Recommendation Report for Planning Permission for Works or Extension to a Dwelling

REF NO: LU/9/19/PL

LOCATION: 64 South Terrace  
Littlehampton  
BN17 5LG

PROPOSAL: Access to garden with gate & reinstatement of wall on west elevation.

BEFORE

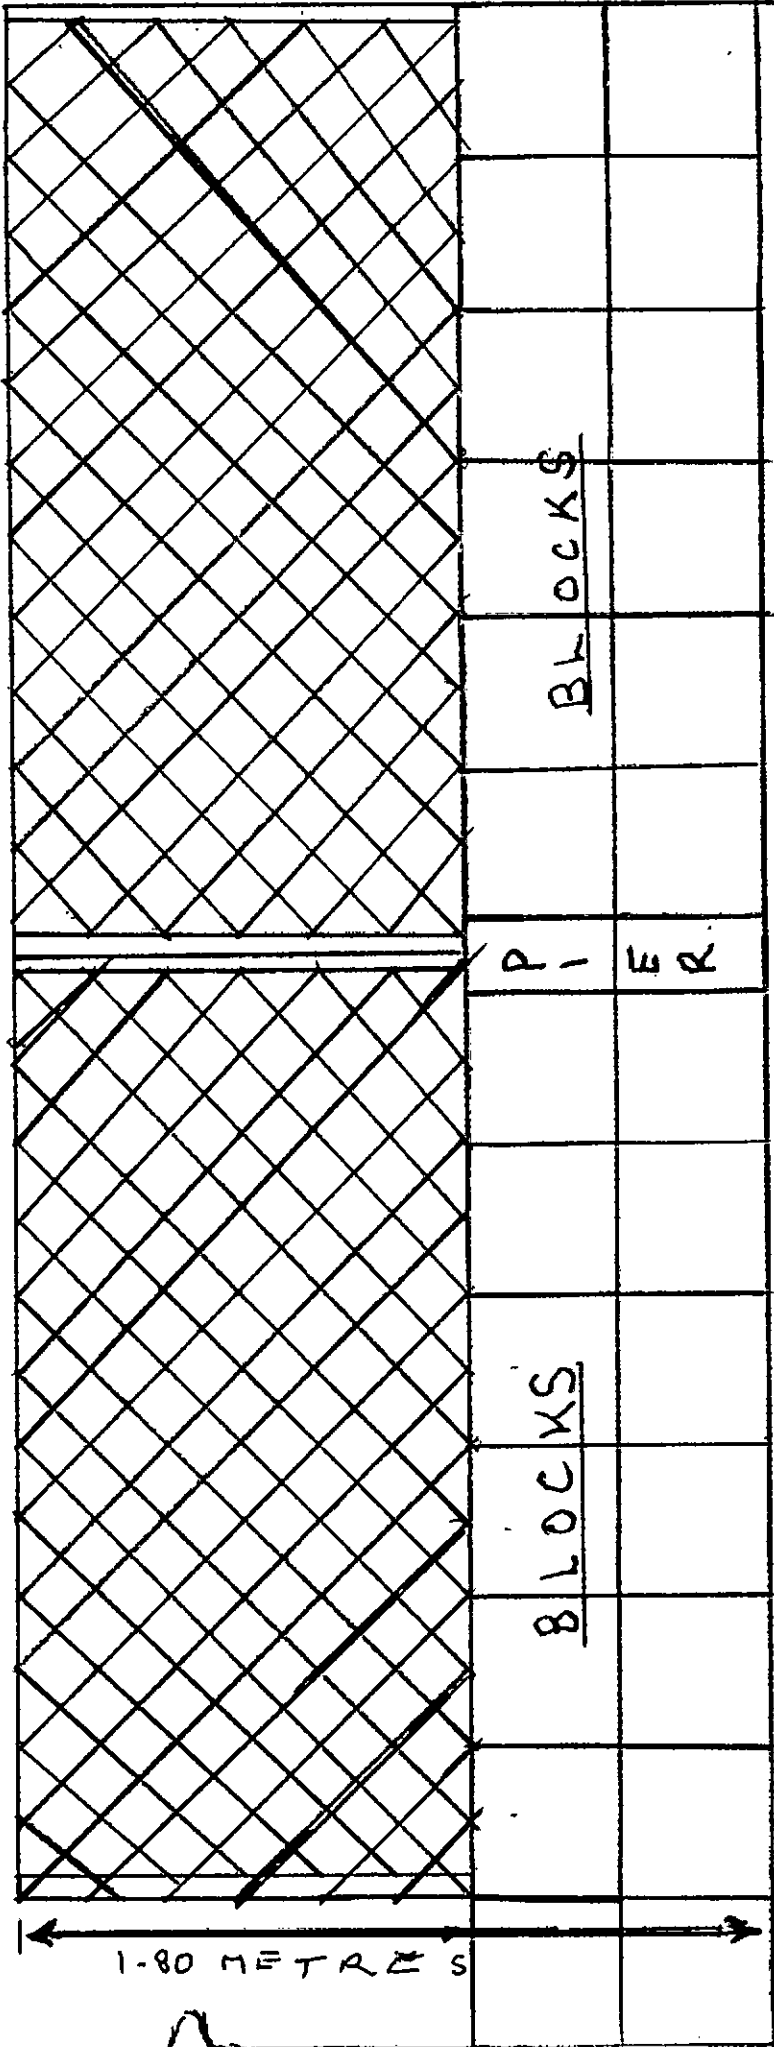
Via a verbal dialogue It was considered that to omit the established trellis running the front boundary wall would be an advantage to the character of south terrace. The insertion of a new gate would not detract from the overall character to its detriment

Currently the garden to the front of the property has access from a domestic (side) gate to a shared area serving as access to the properties above. The proposal seeks to infill this gate access and create a new gate onto the pathway to allow for disability buggy access for the occupant. The removal of the existing trellis is also proposed.

Via verbal dialogue (2/07/2019) - the amended plans show that the trellis element has been removed which is considered a betterment to the character of South Terrace.
